Subject: Rezoning Petition Review

Rezoning Petition #: 22-116

Proposed Zoning: INST (CD)

Location of Property: Approximately 15.30 acres located along the southeast side of Carmel Rd, west of Colony Rd and east of Mooreland Farms Rd.

# RZ-2

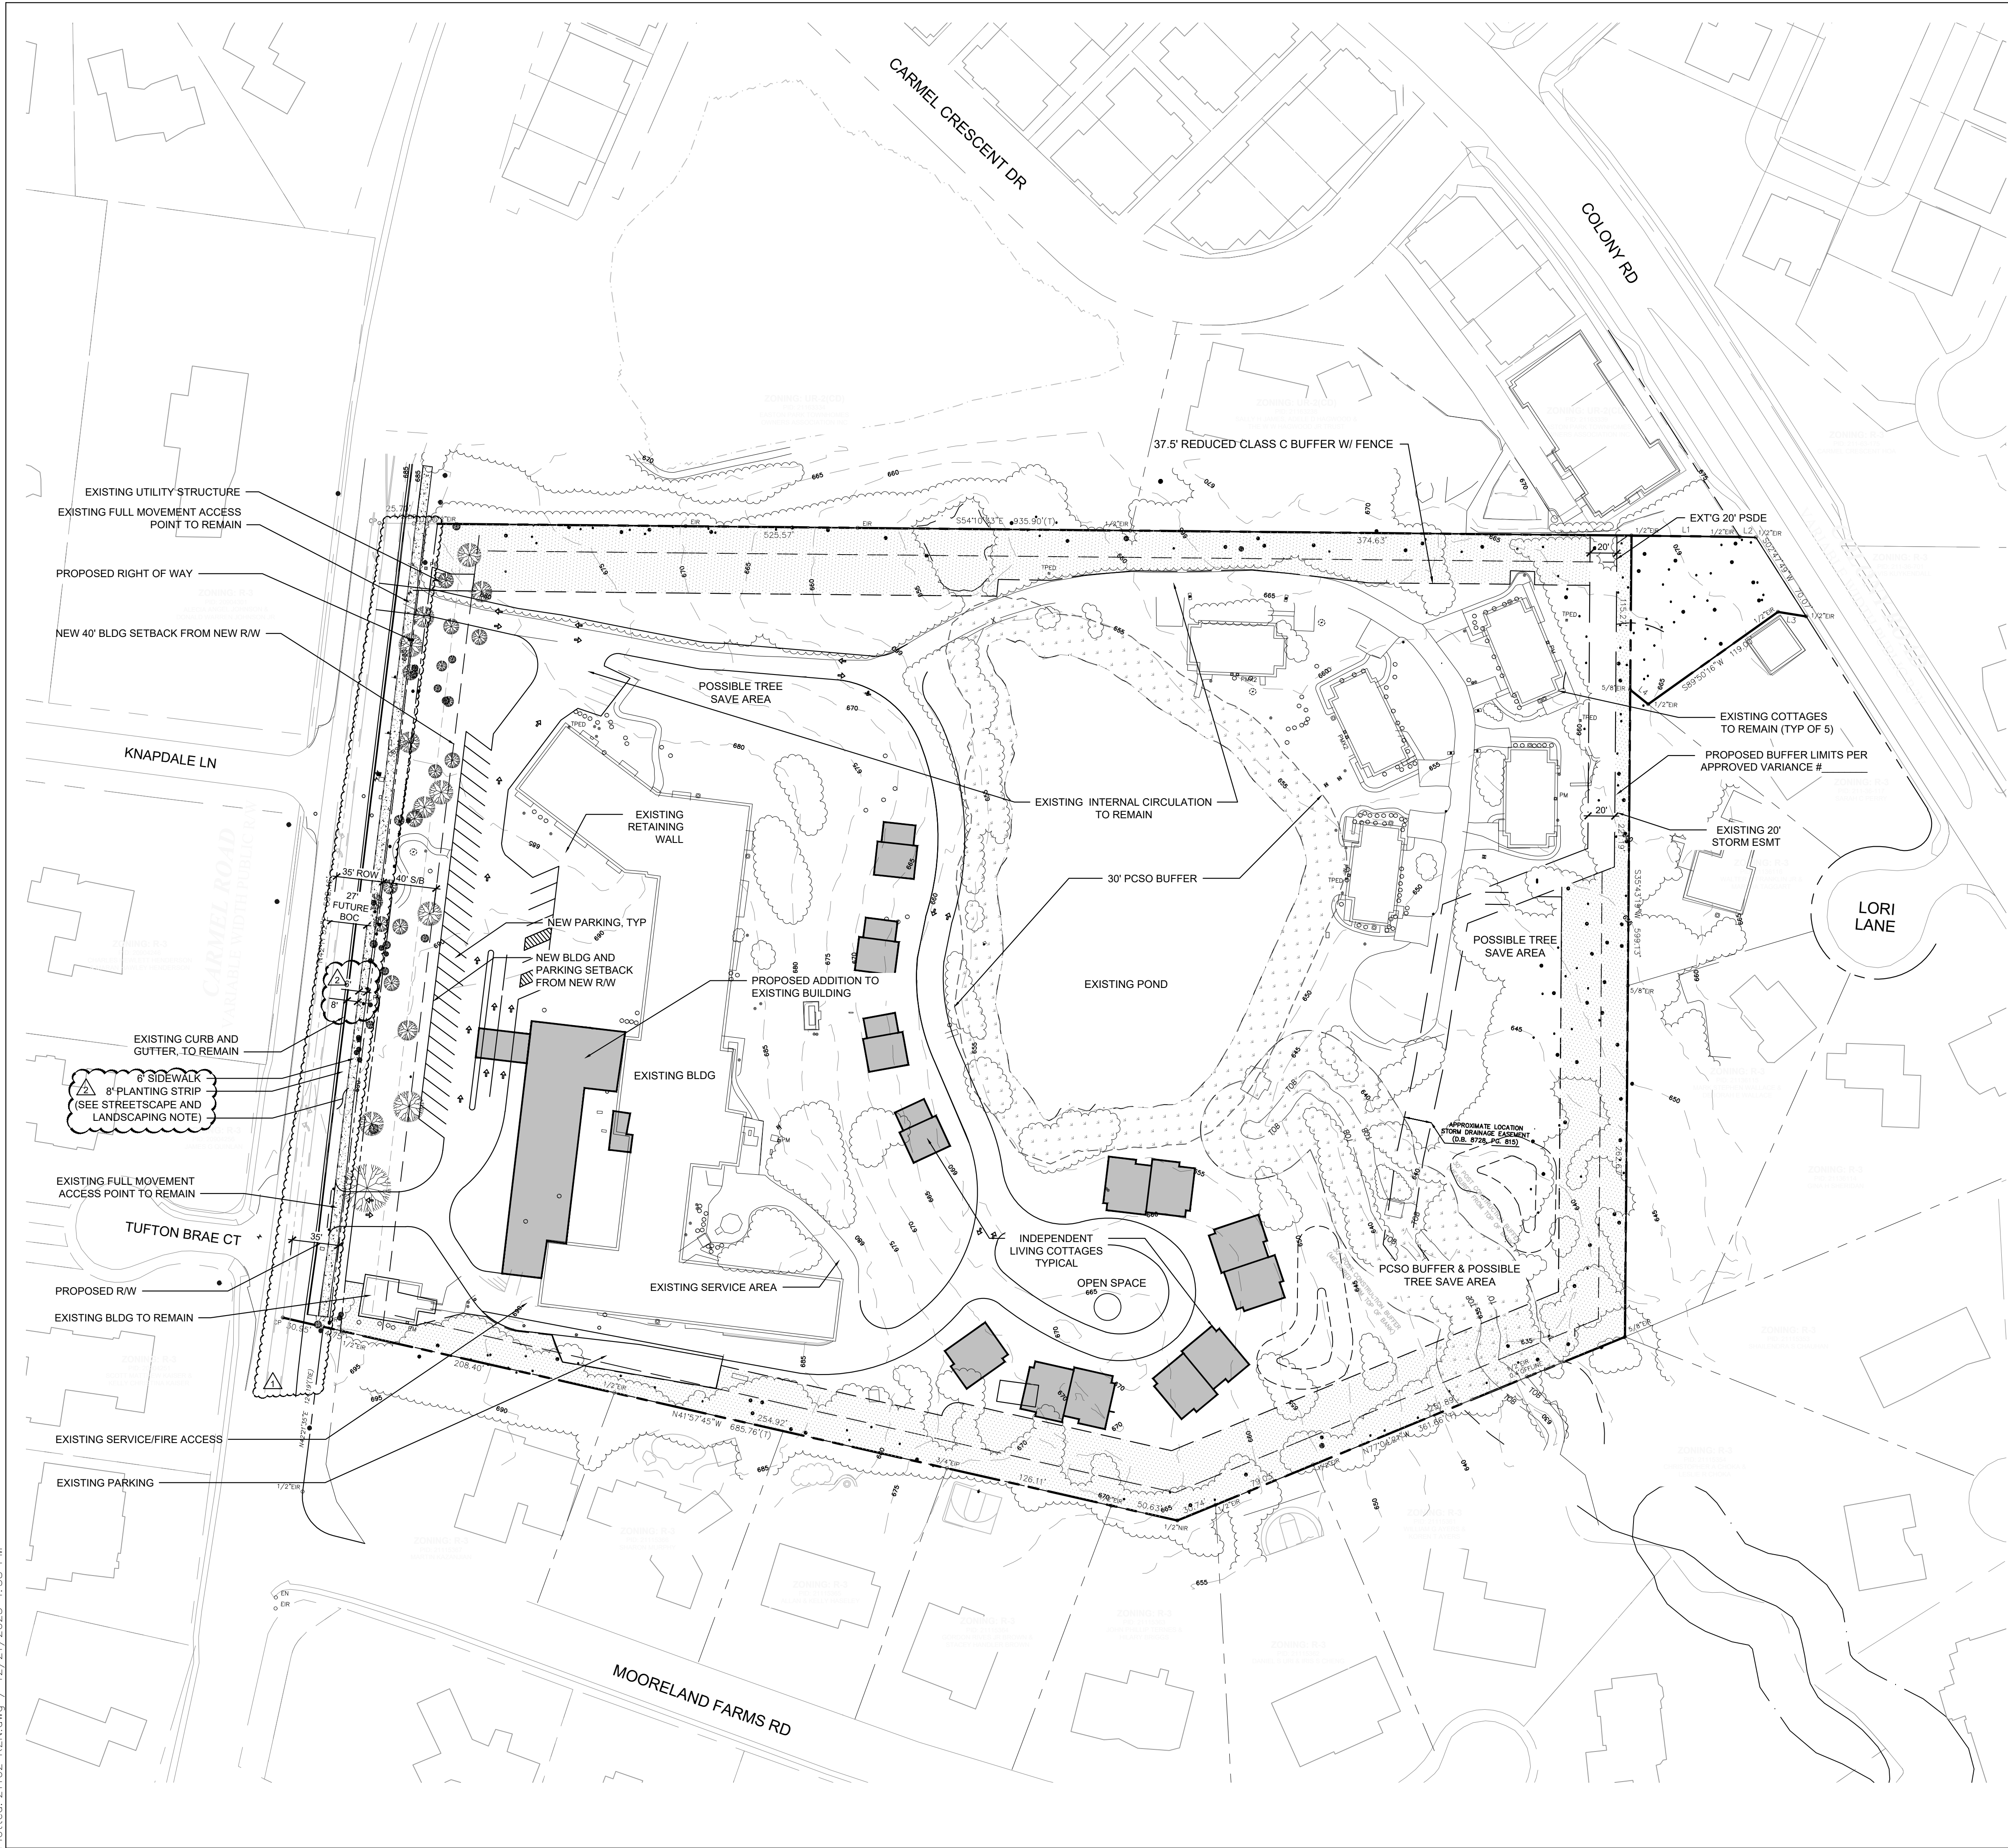
This property drains to McAlpine Creek, which is an impaired/degraded stream, and may contribute to downstream flooding. This project has the opportunity to mitigate future impacts to this stream, therefore, Storm Water recommends placing the following notes on the plan:

For defined watersheds greater than 24% built-upon area (BUA), construct water quality stormwater control measures (SCMs) designed for the runoff generated from the first 1-inch of rainfall for all new and redeveloped BUA associated with the project. SCMs must be designed and constructed in accordance with the Charlotte-Mecklenburg BMP Design Manual.

For defined watersheds greater than 24% built-upon area, control the entire volume for the 1-year, 24-hour storm for all new and redeveloped BUA associated with the project. Runoff volume drawdown time shall be in accordance with the Charlotte-Mecklenburg BMP Design Manual.

For commercial projects with greater than 24% BUA, control the peak to not exceed the predevelopment runoff rates for the 10-yr, 6-hr storm and perform a downstream flood analysis to determine whether additional peak control is needed and if so, for what level of storm frequency, or if a downstream analysis is not performed, control the peak for the 10-yr and 25-yr, 6-hour storms.

For residential projects with greater than 24% BUA, control the peak to not exceed the predevelopment runoff rates for the 10-year and 25-year, 6-hour storms or perform a downstream analysis to determine whether peak control is needed, and if so, for what level of storm frequency.
